Re: BP#2016-02463 - 12 Taylor Street (Units 1 & 3)

I am handling the plan review for the above building permit.

*NEW PROPOSED FLOOR PLAN FOR 1ST FLOOR

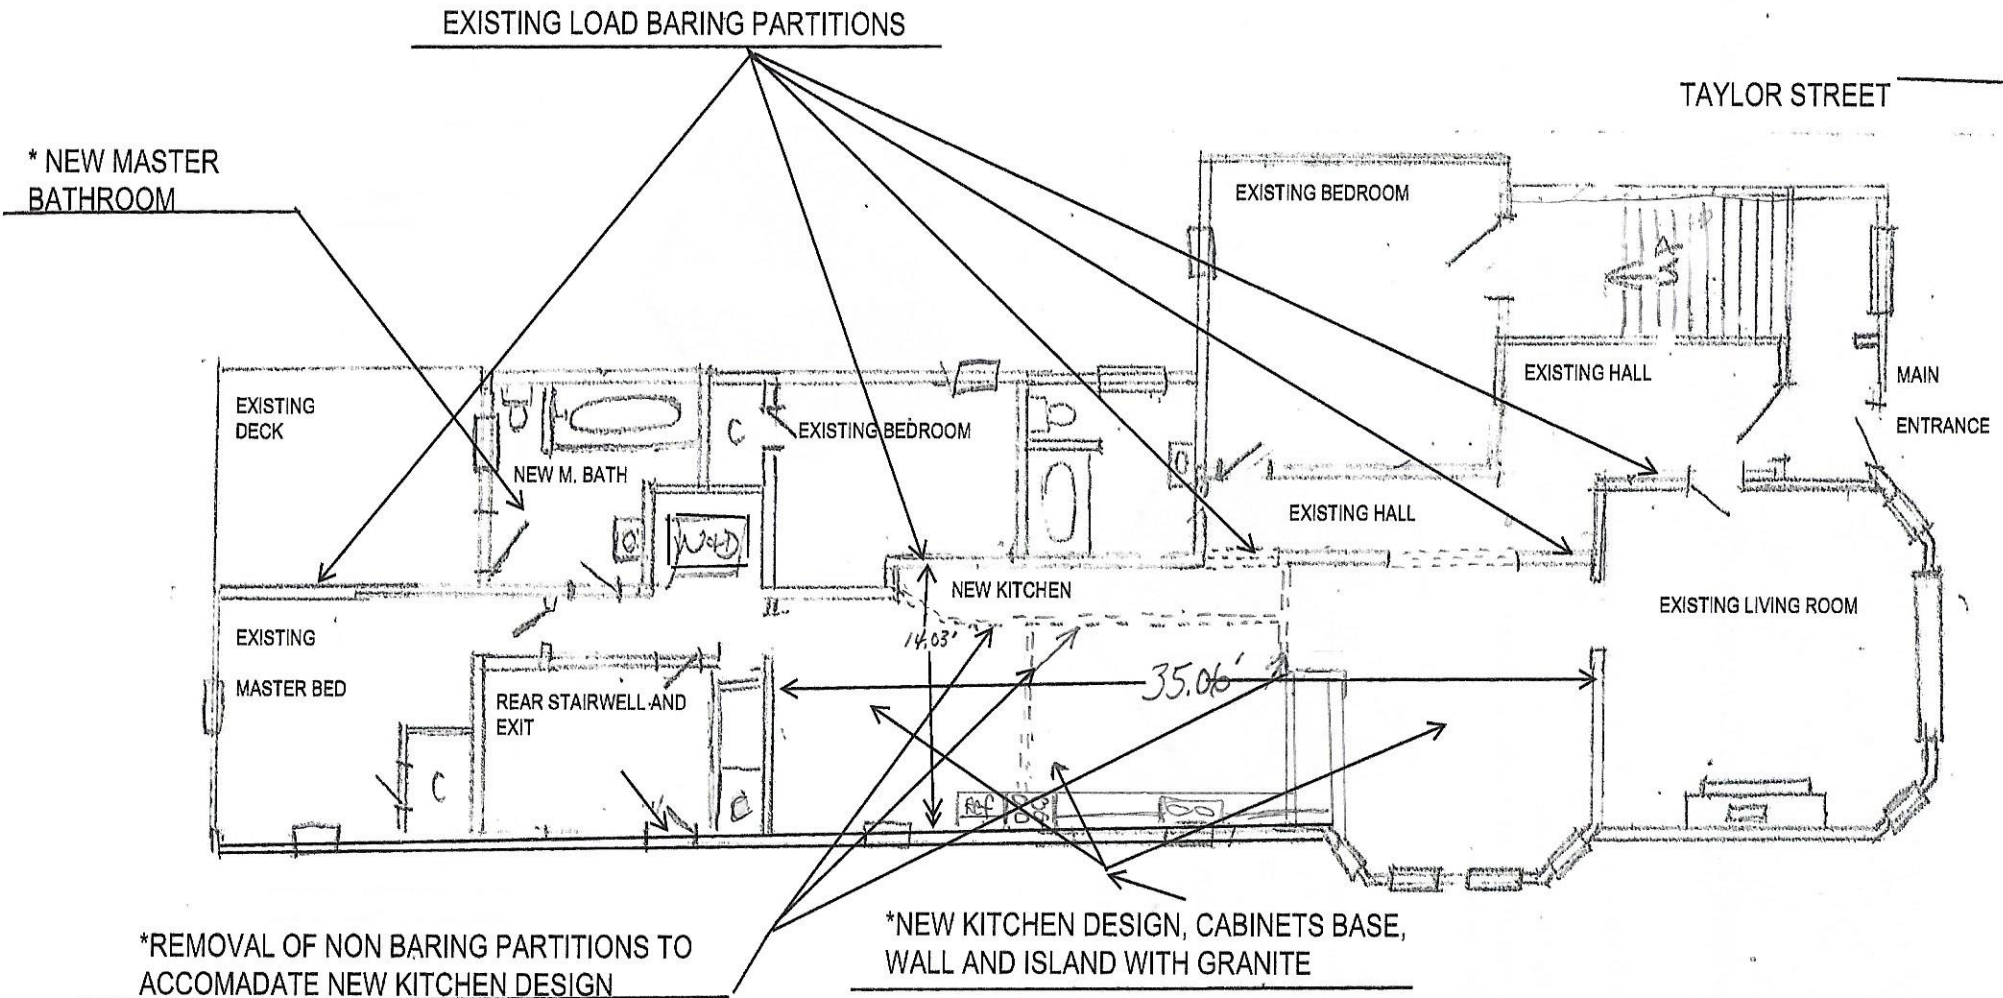
1. Is the proposed scope of work demolition only or does the scope of work include complete renovation of the kitchens in units 1 and 3?
2. Clarify what the scope of work is associated with the new master bathroom for units 1 & 3? Is the bathroom renovations part of this permit?
3. Clarify if the non-bearing partitions being removed will impact the existing ceilings. Given the work being done, continuity of separation of horizontal assemblies is to be maintained.

1. The kitchen will be receiving a renovation including new cabinets and appliances, we are repairing the existing floor
2. The new master bathrooms will require a tiled floor, new bathtub, new toilet, and a new vanity. Plumbing in this area already existed and will be tied in upon installation
3. The ceilings will not be affected but I am asking for additional clarity on this question so I can answer you fully

EXISTING LOAD BARING PARTITIONS AND CEILING JOIST

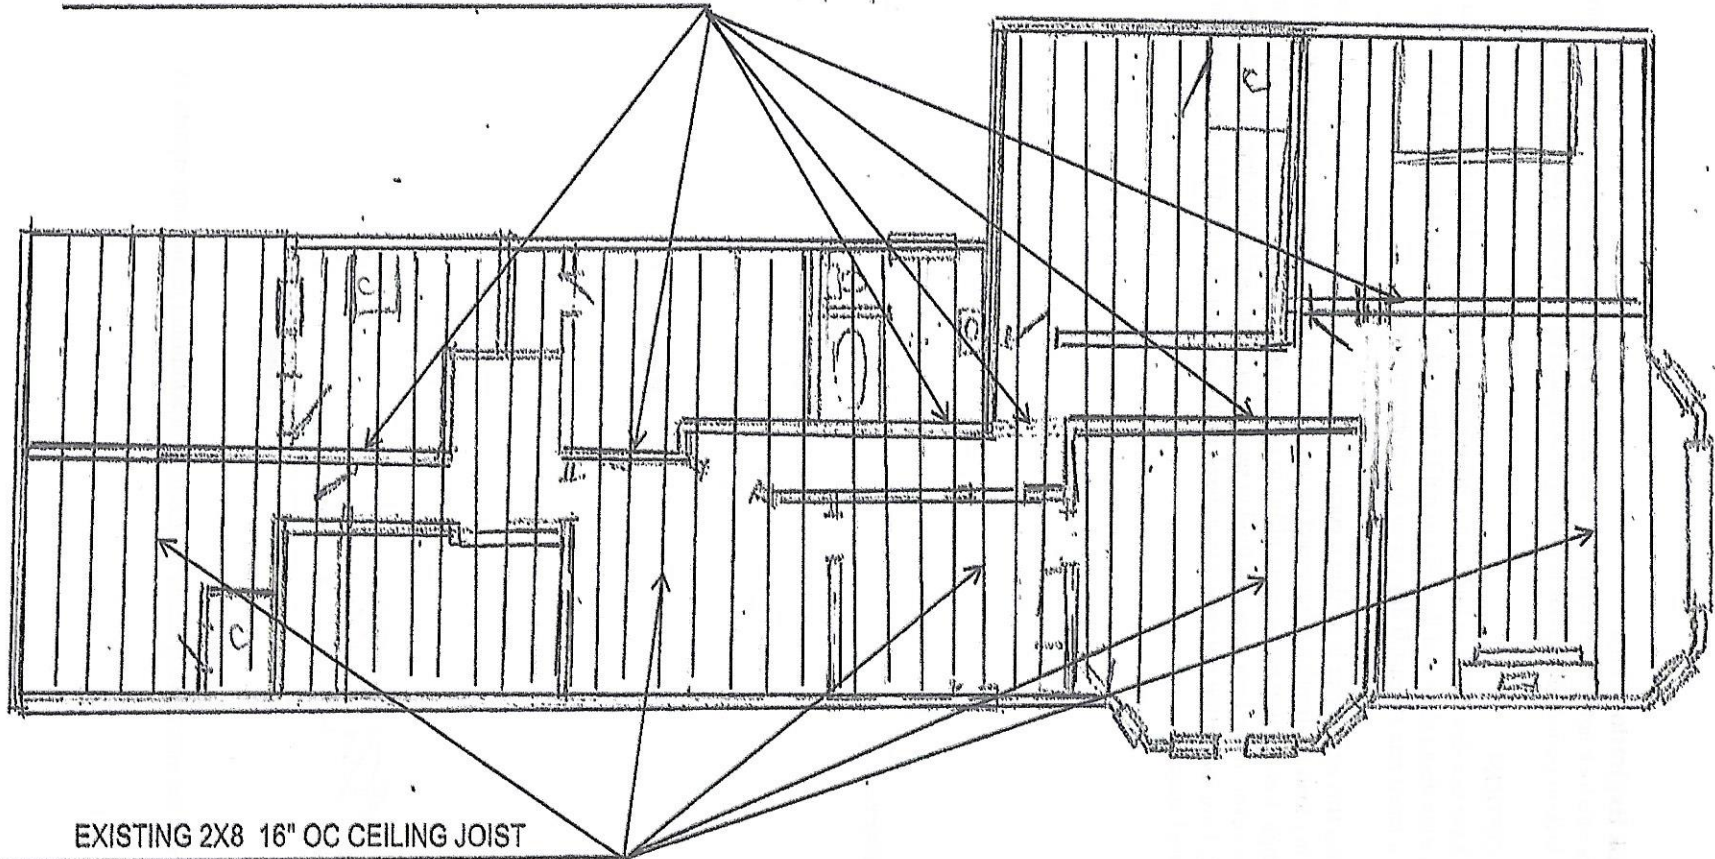
The section of the building code I am referencing is Section 712 Horizontal Assemblies. Given this is a multi-family dwelling unit, the code requires separation both vertically and horizontally between dwelling units. I am questioning if the horizontal assembly is being affected during the construction which would then impact the separation between the unit under renovation and the dwelling unit above.

To secure the horizontal fire barrier between units and bring the ceiling up to code we intend to use 5/8" Fire Code C Core gypsum panels. I have also attached the diagram we used at 87 Emery St two months ago, it shows our current flooring of 1" sub and finished floor

After speaking with the contractors this morning the ceiling is in disrepair and needs to be brought up to code, but none of the non barring walls being removed will affect the assembly. As soon as we receive the permit the damaged ceiling will be brought up to code.
